A47/A11 Thickthorn Junction

9.11 Applicant's Written Summary of Oral Submissions at ISH1

A47/A11 Thickthorn Junction
Development Consent Order 202[x]

**APPLICANT'S WRITTEN SUMMARY OF
ORAL SUBMISSIONS AT ISH1**

Figure 1. Proposed footbridge

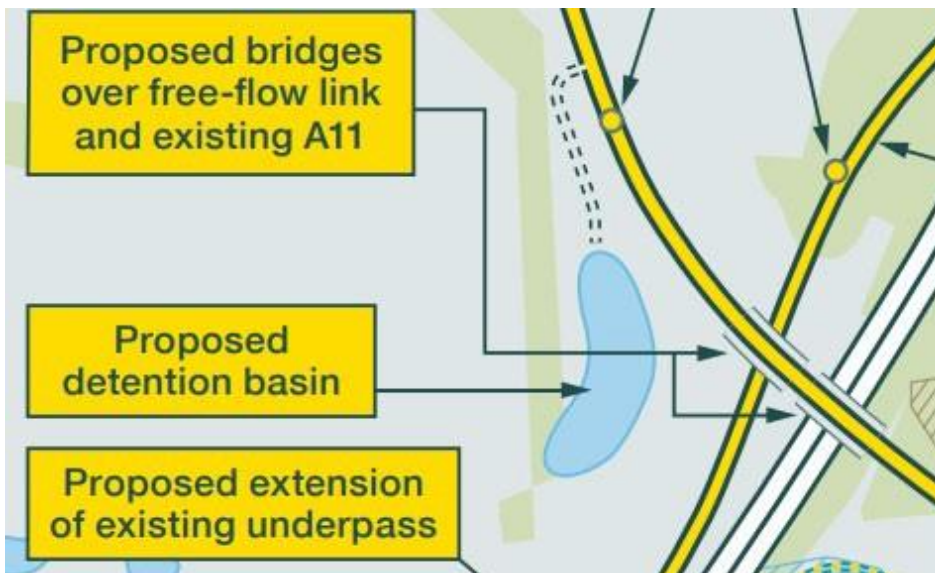
2.2	The ExA asked the Applicant to explain the differences between the existing and proposed footbridge?	As noted in the 2018 Scheme Assessment Report, the existing footbridge accommodates a 1.8m wide footway with 1.1m high parapets and this is stepped (with a ramp provided on the right hand side to allow cyclists to wheel across). This current footbridge is not suitable for equestrians and is not compliant with the Equalities Act 2010. WCH surveys confirmed that the existing footbridge is regularly used by cyclists and the occasional equestrian. The new bridge being proposed will be located approximately 40m south of existing bridge so the detour is approximately 70m. It has been designed to keep the span of the structure to a minimum and to use the existing topography to reduce visual impacts. REP2-006 explains how the new footbridge is compliant with CD 143 designing for walking, cycling and horse riding, with maximum gradients of 5%, together with a 3.5m width to facilitate users in both directions. The Applicant has been cognisant of the advice provided by the British Horse Society and its advice leaflet on bridges, gradients and steps in England and Wales. A 1.8m high parapet will be provided and surfacing will be rubber compound or similar. The footbridge will be formed of a single span steel truss infrastructure, so that it can be prefabricated offsite and installed during a single road closure to minimise the impact on the road network.	The Applicant has no further comments.

Appendix 1: Proposed Site Layout

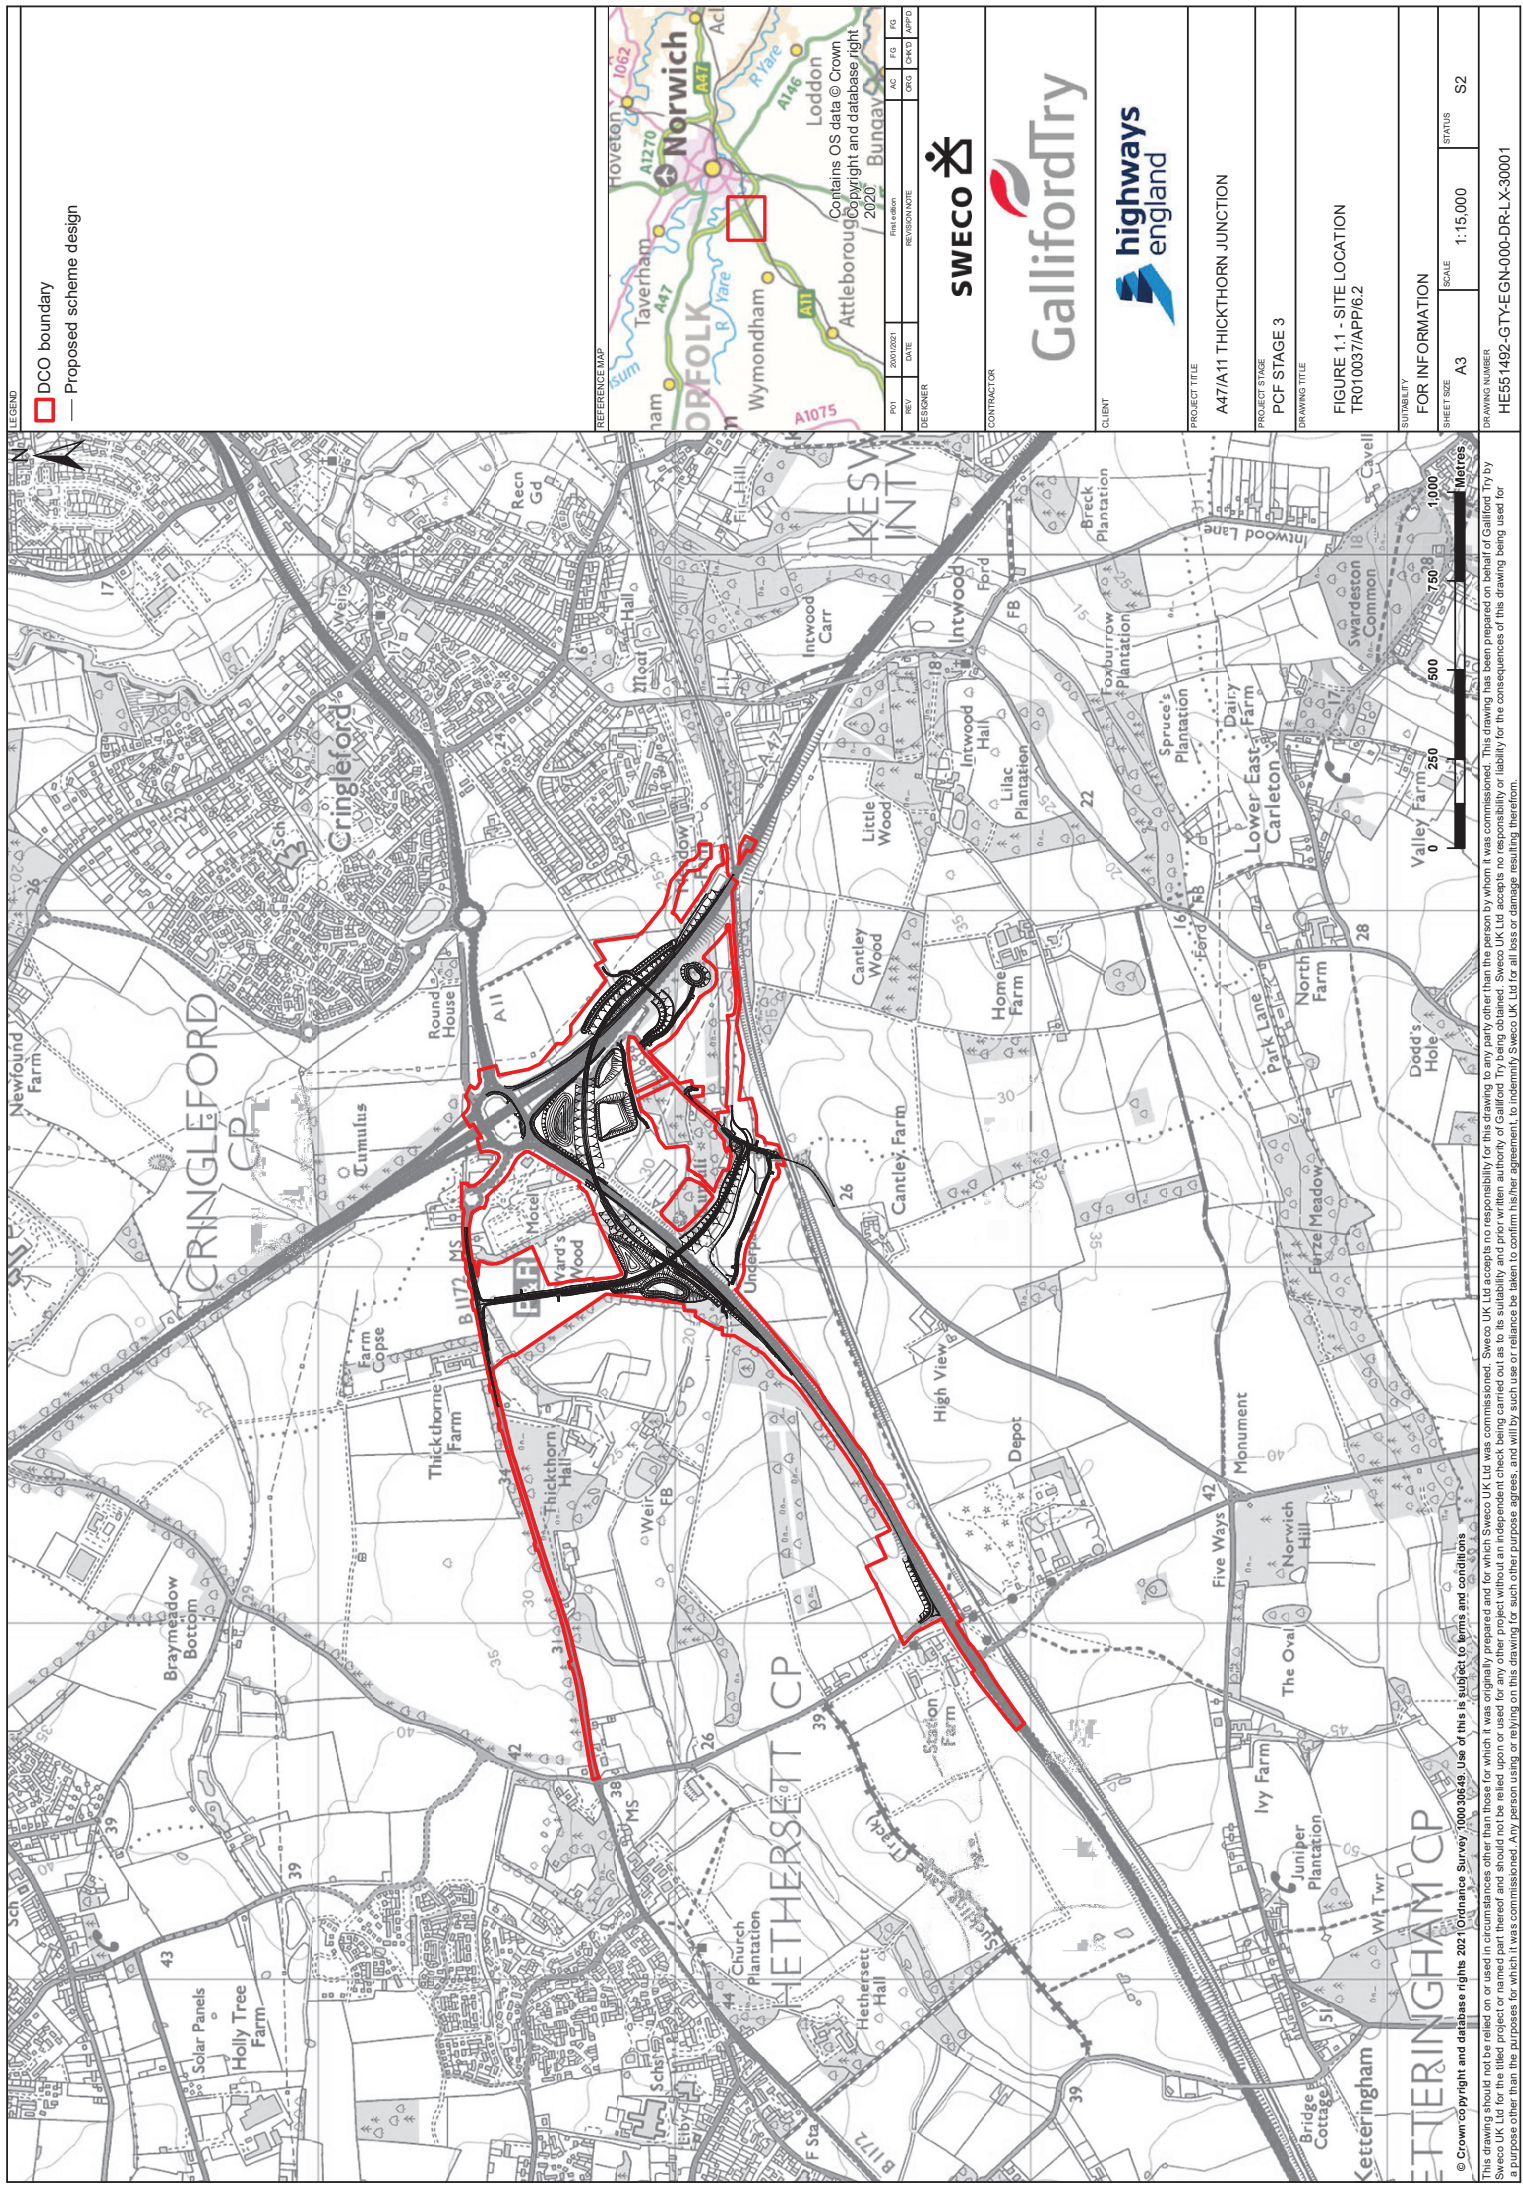
3.5	<p>The ExA asked, with regards trees T13 and T14 on the AIA, whether there any design scope to retain those or if there is no avoidable way of those being lost through the scheme?</p>	<p>The Applicant confirmed that there is no way to retain these veteran trees: one is affected by alignment of Cantley Lane Link Road and one by A11 and A47 connector road. This is driven by site constraints in local area and DMRB design and safety standards in terms of alignment geometry.</p> <p>The constraints in the area that would affect the alignment of the roads are the scheduled monument, the park and ride and the proposed extension, significant existing utility infrastructure</p>	<p>The Applicant has no further comments.</p>
